WRITTEN REPRESENTATION ON BEHALF OF NORFOLK WILDLIFE TRUST

Application by East Pye Solar Limited for the East Pye Solar Development Consent Order

Planning Inspectorate Reference: EN0110014

**Figure 8.4 - Irreplaceable Habitats within 2km**  
 Sheet 4 of 6  
 Revision A

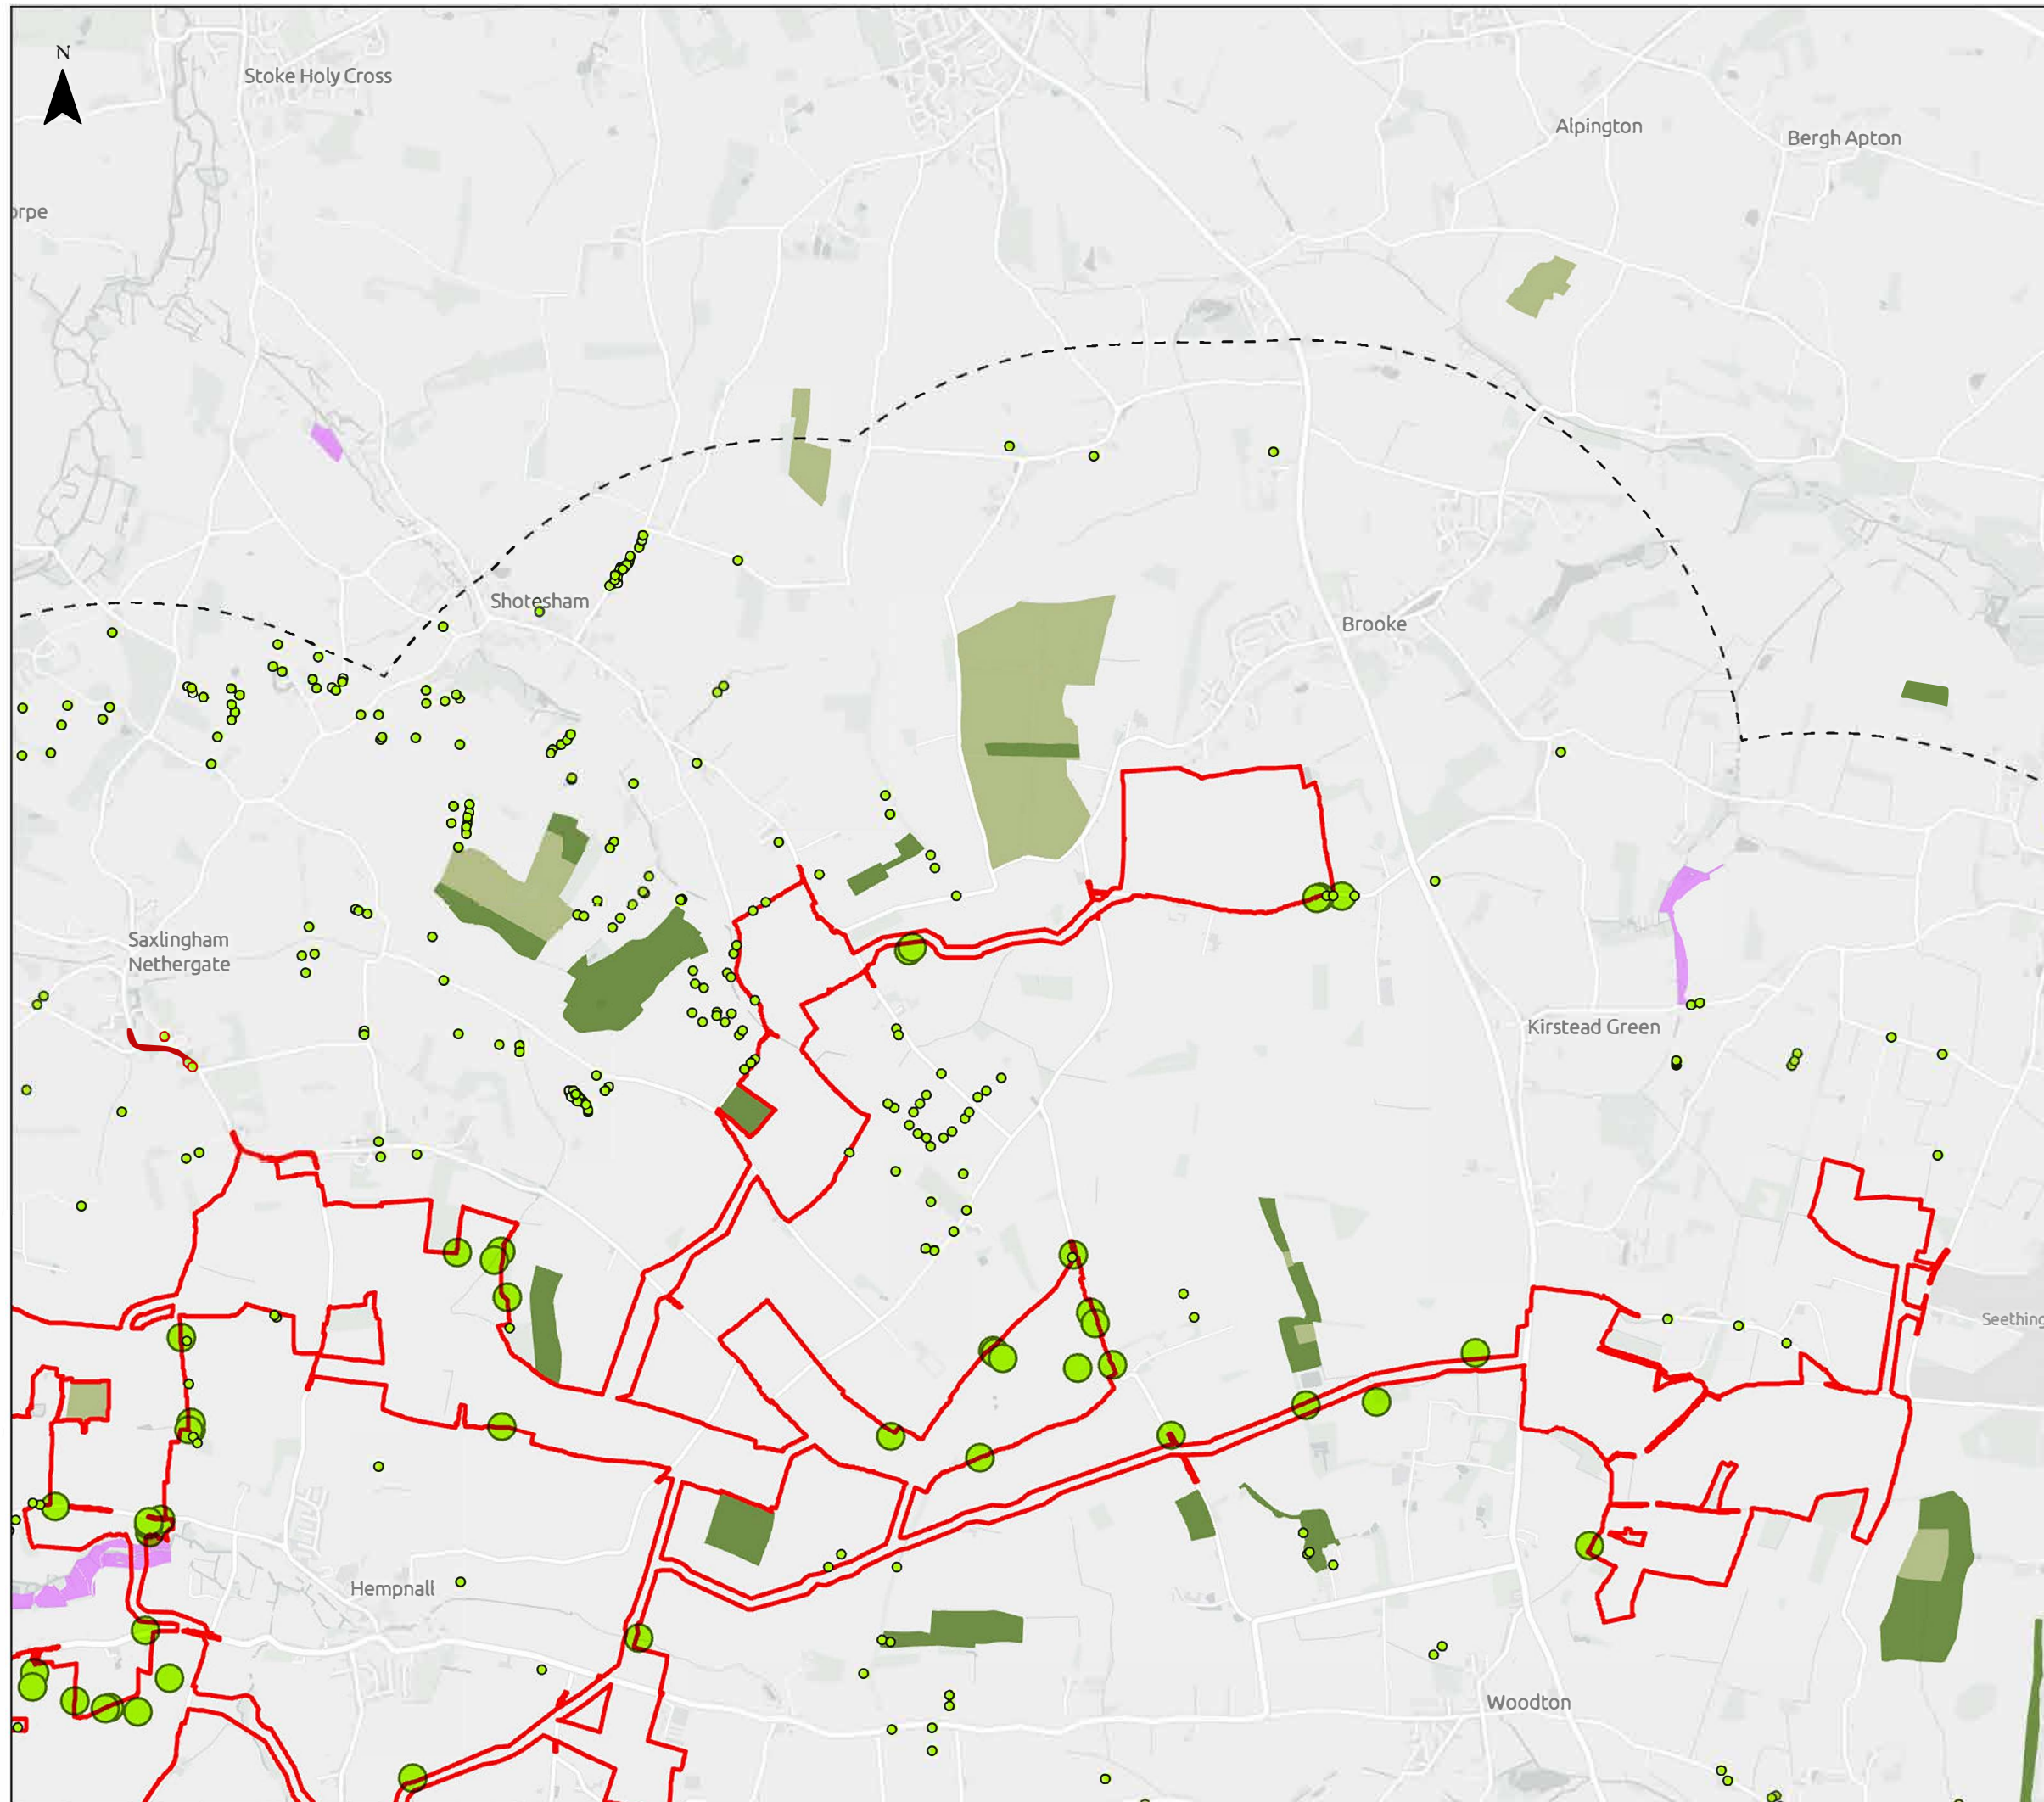
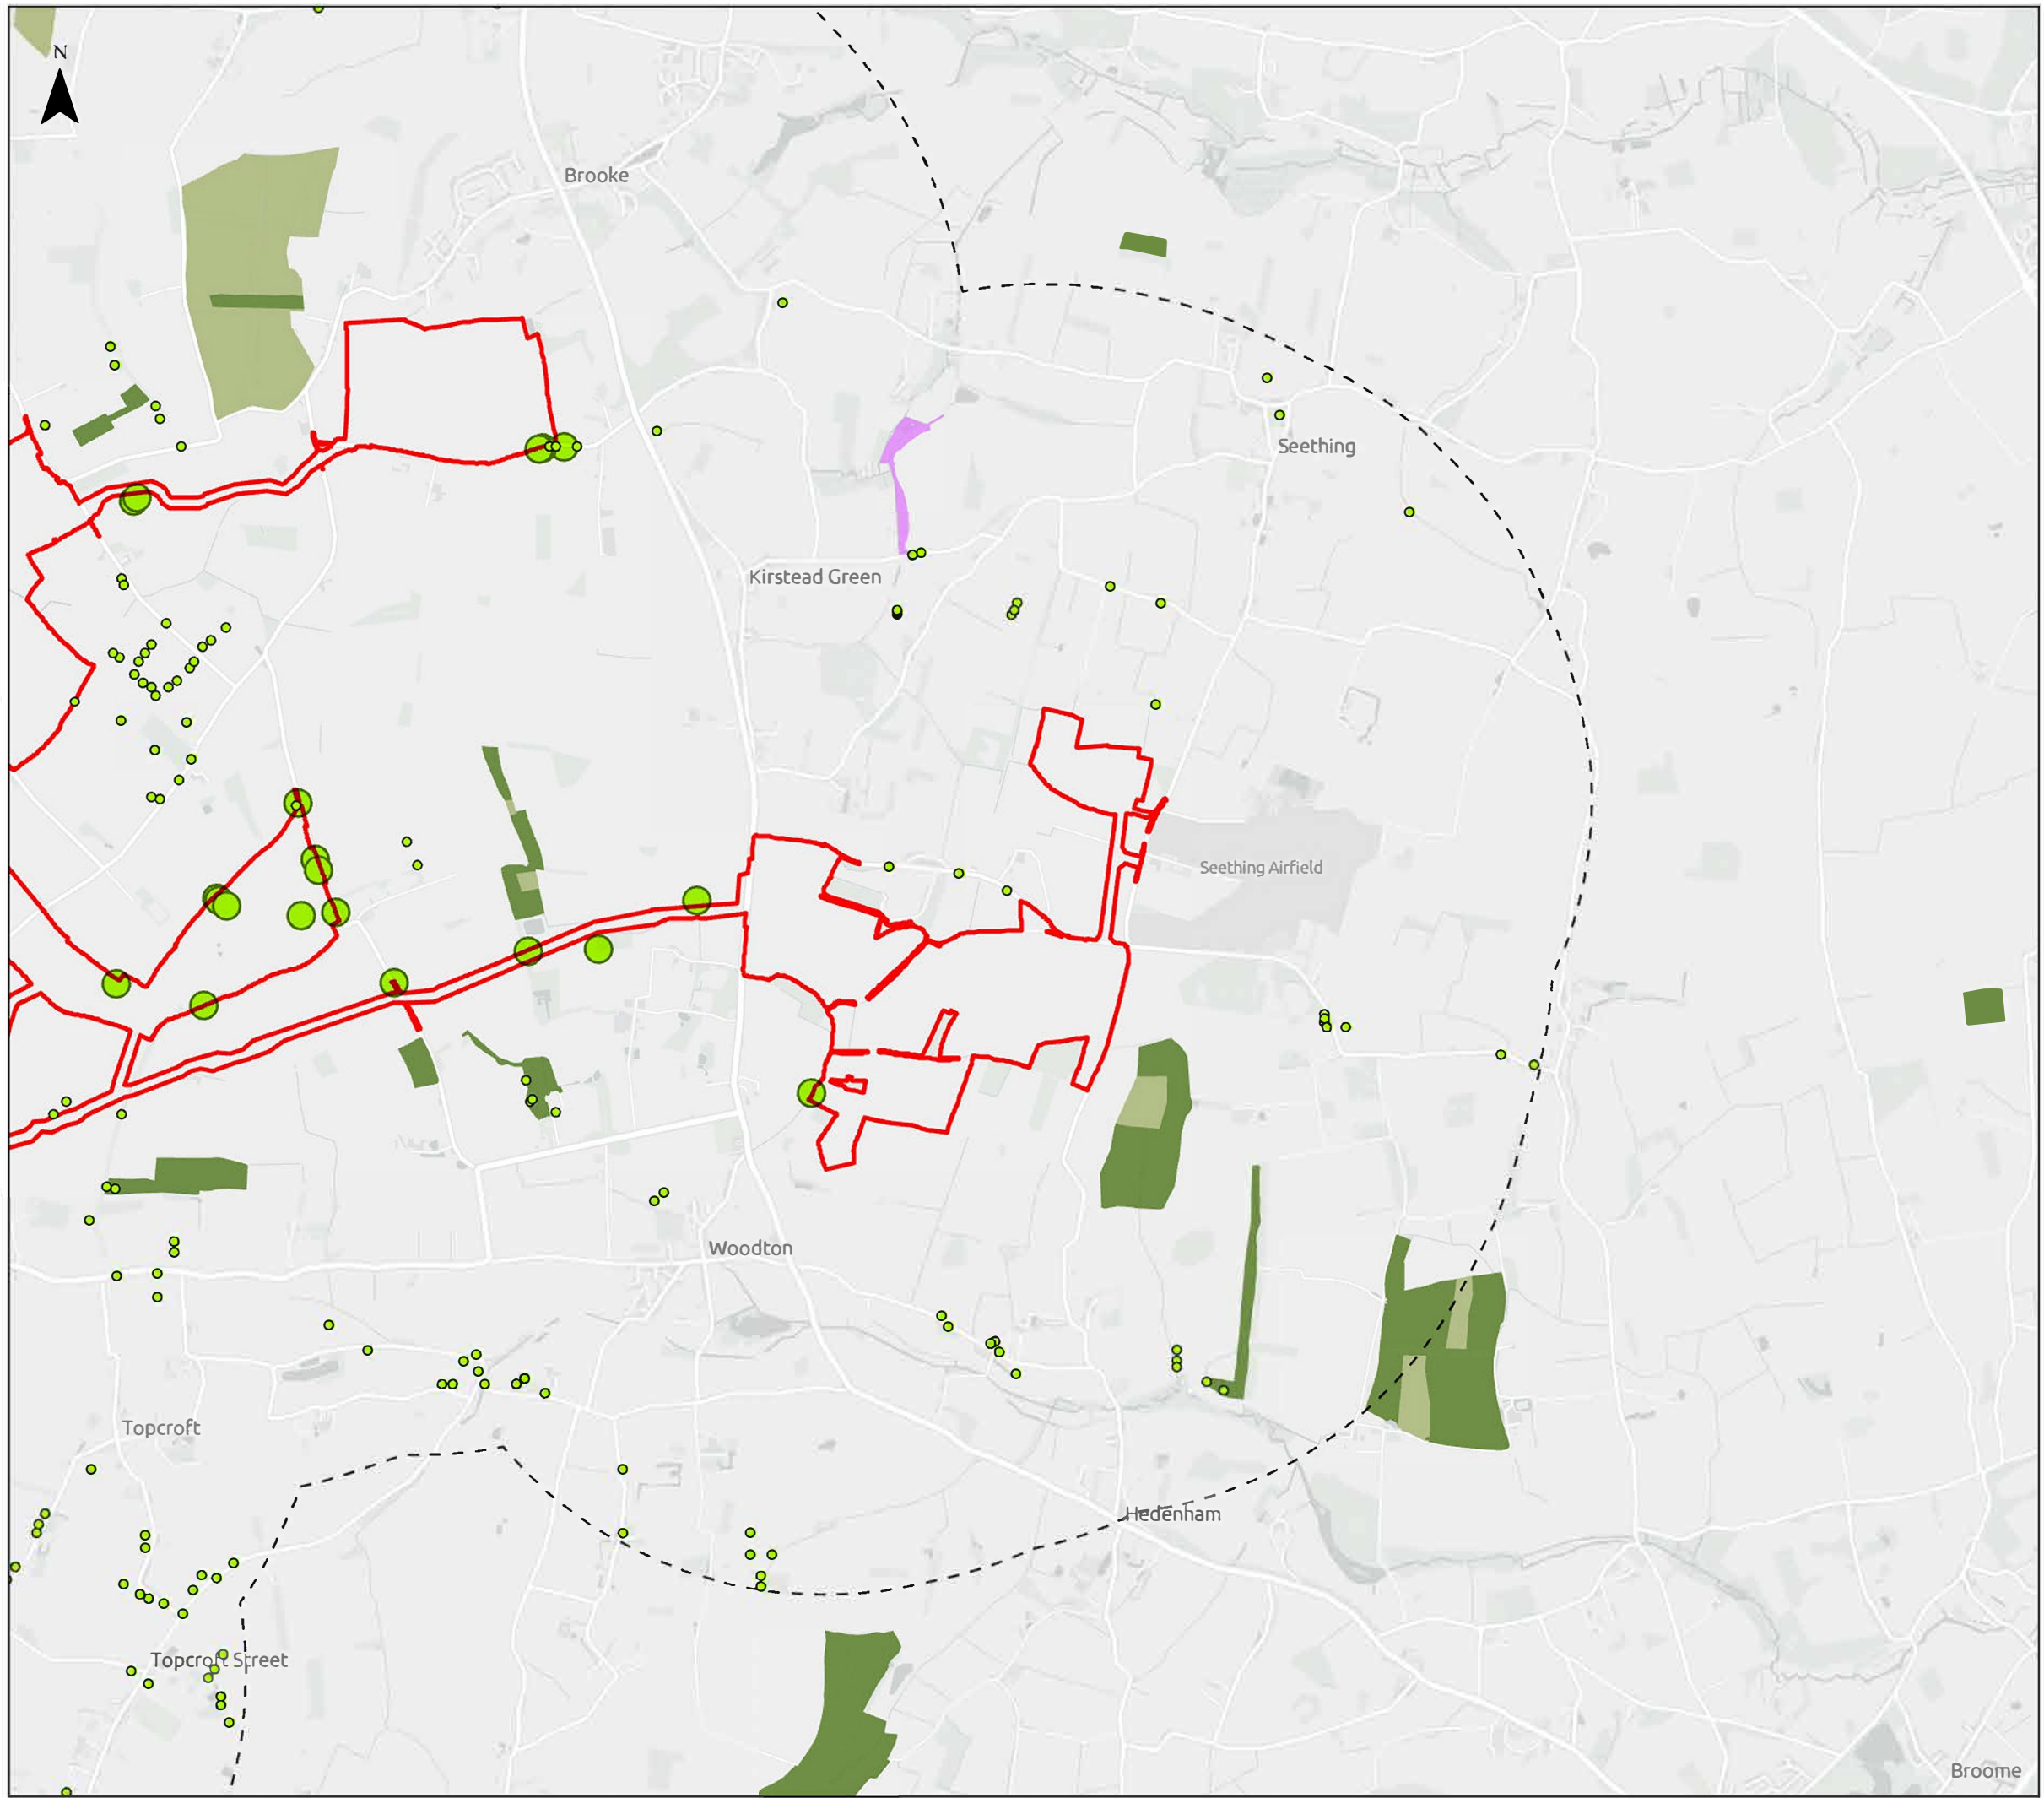
- This includes an area of lowland fen habitat within the cable route corridor. Lowland fen is an irreplaceable habitat and is highly sensitive to hydrological change, groundwater disturbance, compaction and pollution. It is stated that Horizontal Directional Drilling (HDD) will be used and the Outline CEMP includes design measures to reduce impacts through run-off control, pollution prevention and dust control during construction and specifies Stand-off distances of 30m from the CWS, which we welcome.

- However, section 4.4 of the Outline Cable Route Construction Statement states that the technology used for the HDD will be determined by feasibility studies carried out at each crossing during the detailed design stage and in accordance with a method statement. The Outline CEMP also states that a Hydrogeological Risk Assessment will be undertaken, "if required". Although the applicant states that HDD will pass beneath the fen at a depth of at least 5m, insufficient evidence has been provided to demonstrate that construction activities will not affect groundwater conditions or the hydrological processes upon which the fen depends. The applicant has also stated that a Water Management Plan will form part of a detailed CEMP and will include details of pre-construction, construction, and post-construction water quality monitoring. Further details are required to allow proper scrutiny.

- The oCEMP confirms that the precise locations of HDD entry and exit points will only be determined at the detailed design stage. Without this information it is not possible to fully assess the ecological impacts or determine whether the proposed buffer distances are sufficient. HDD entry and exit locations should be identified prior to examination close.
